CHURCH AT BENT GRASS MEADOWS
SITE DEVELOPMENT PLAN

SITE DEVELOPMENT PLAN
COVER

PCD File No.
PPR2622

PCD FILE NO.: SF268

1 EAST ELEVATION
A200 1/8" = 1'-0"

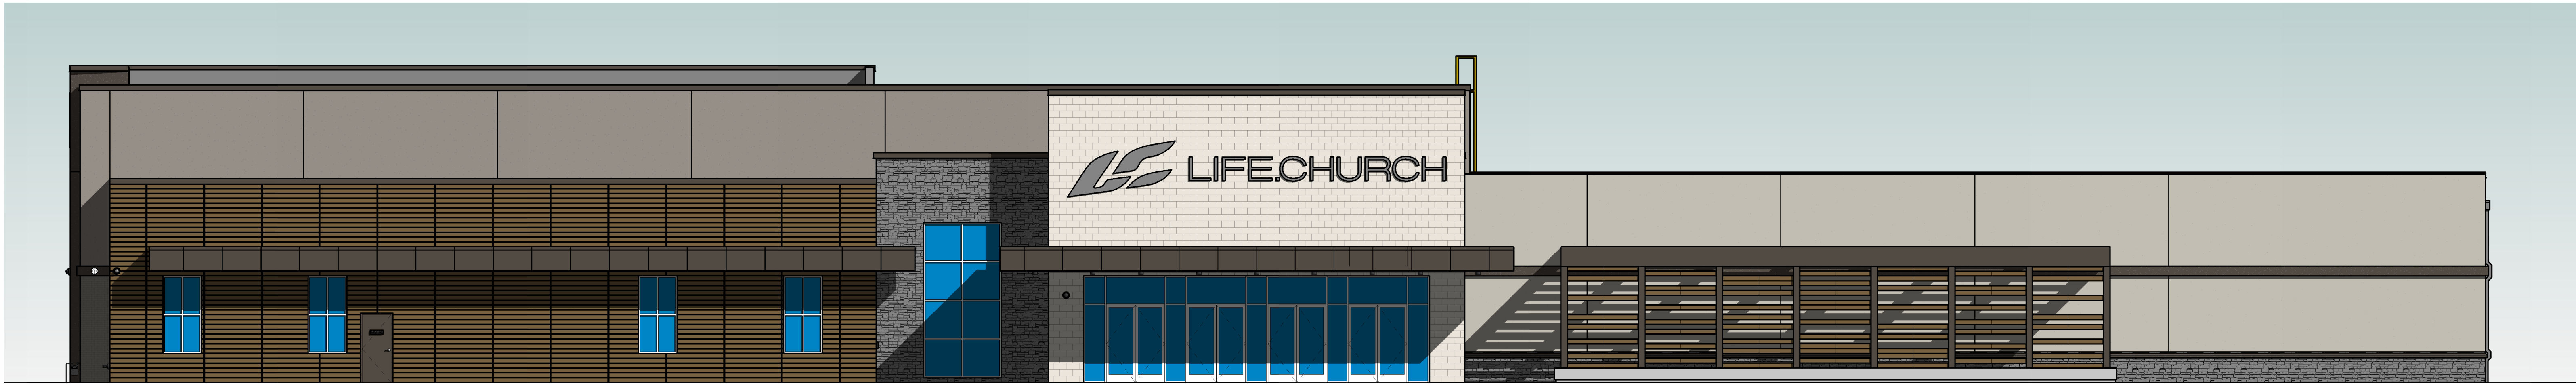
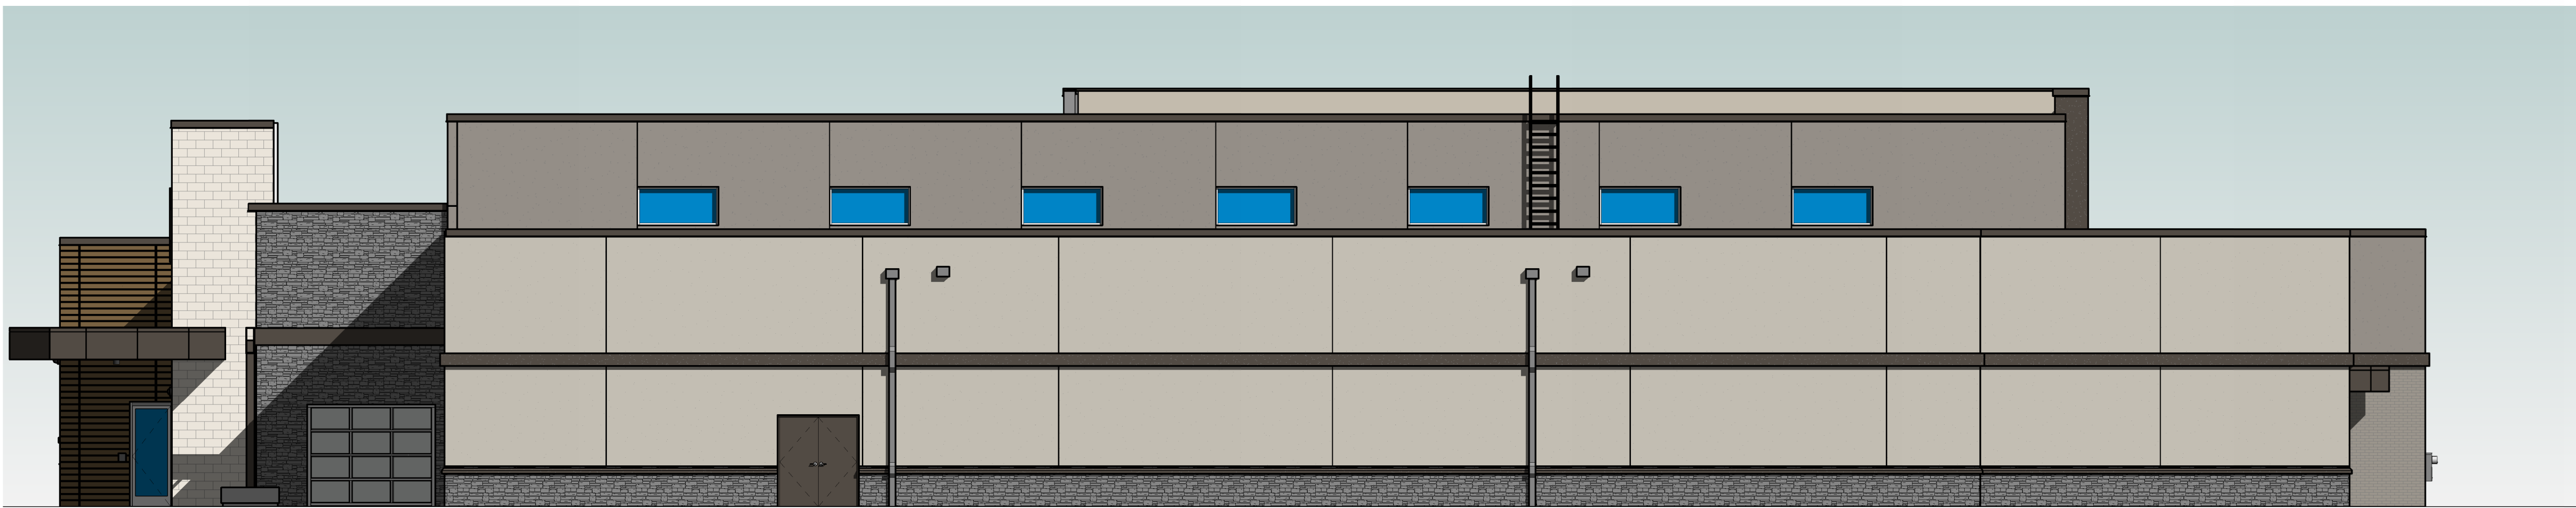
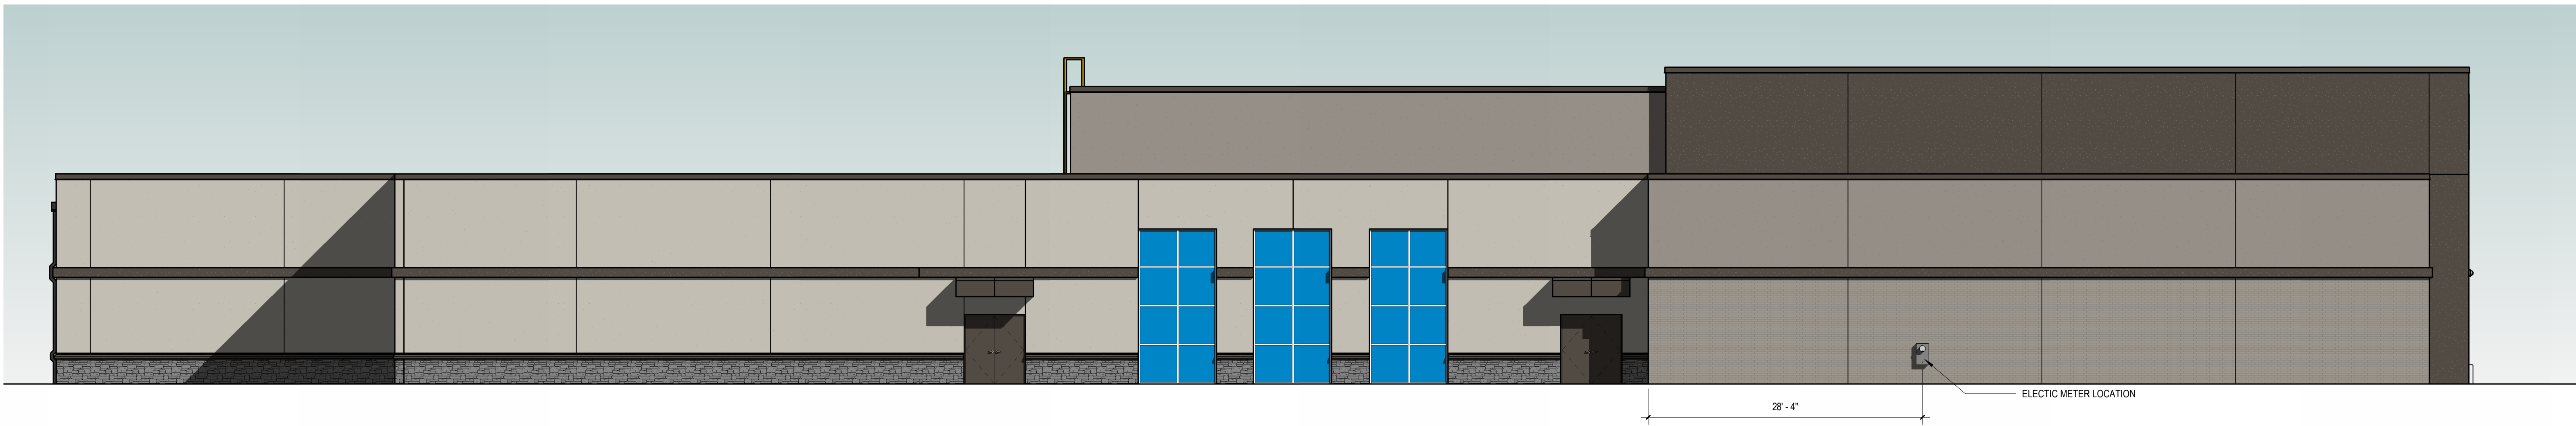
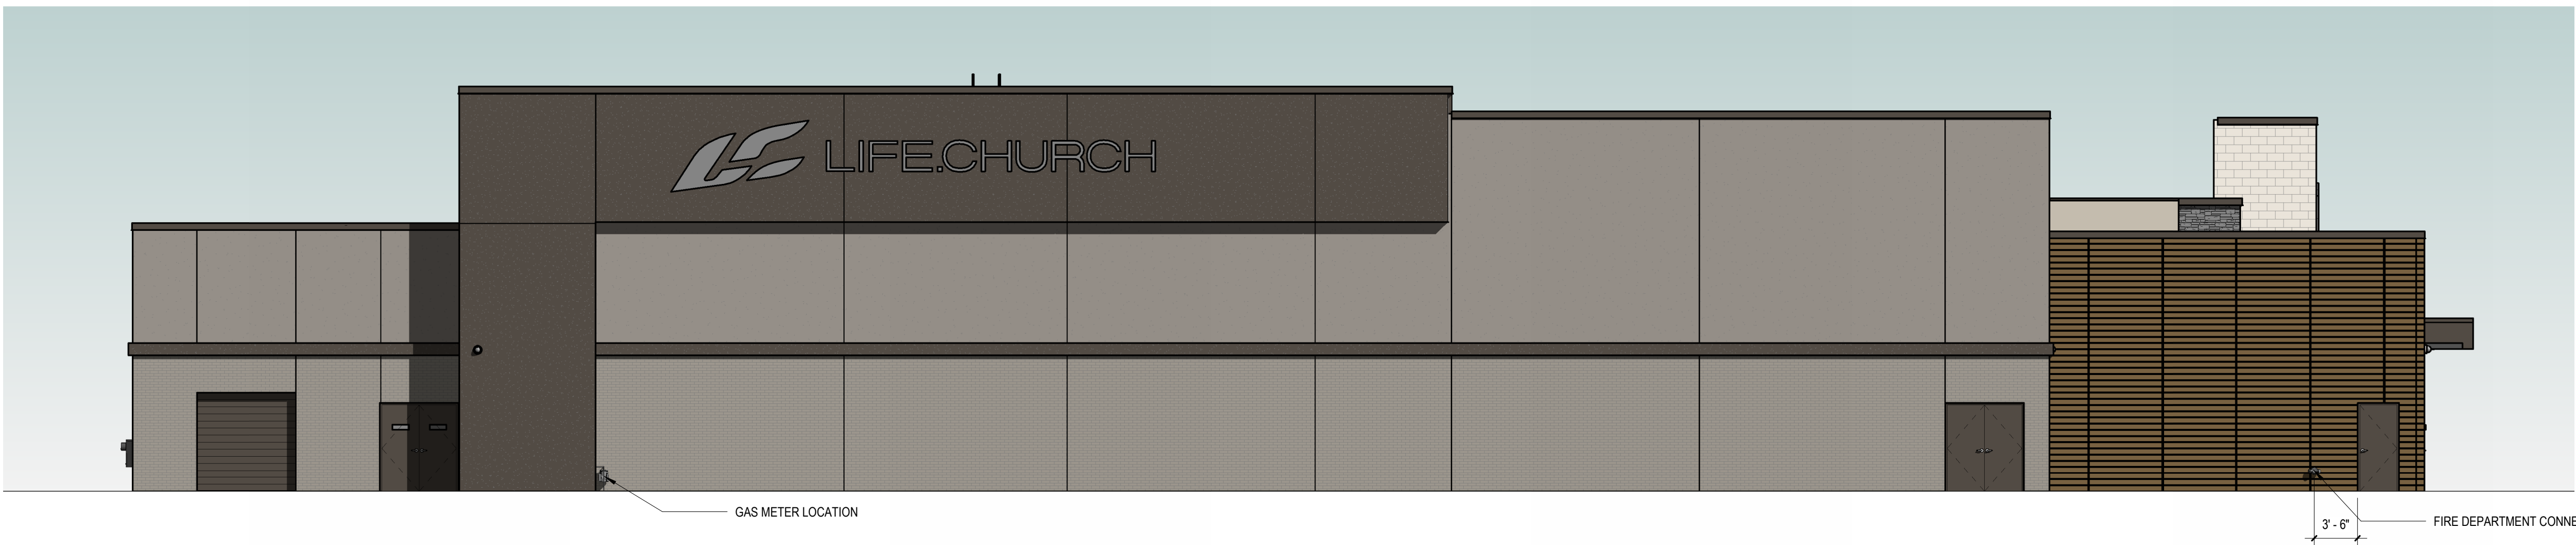
Please add additional elevation information to include structure height, length, width etc.

Full elevation data is required to review sign plan.

FAL Realty Architecture Group Response: Additional information now included with dimensioning.
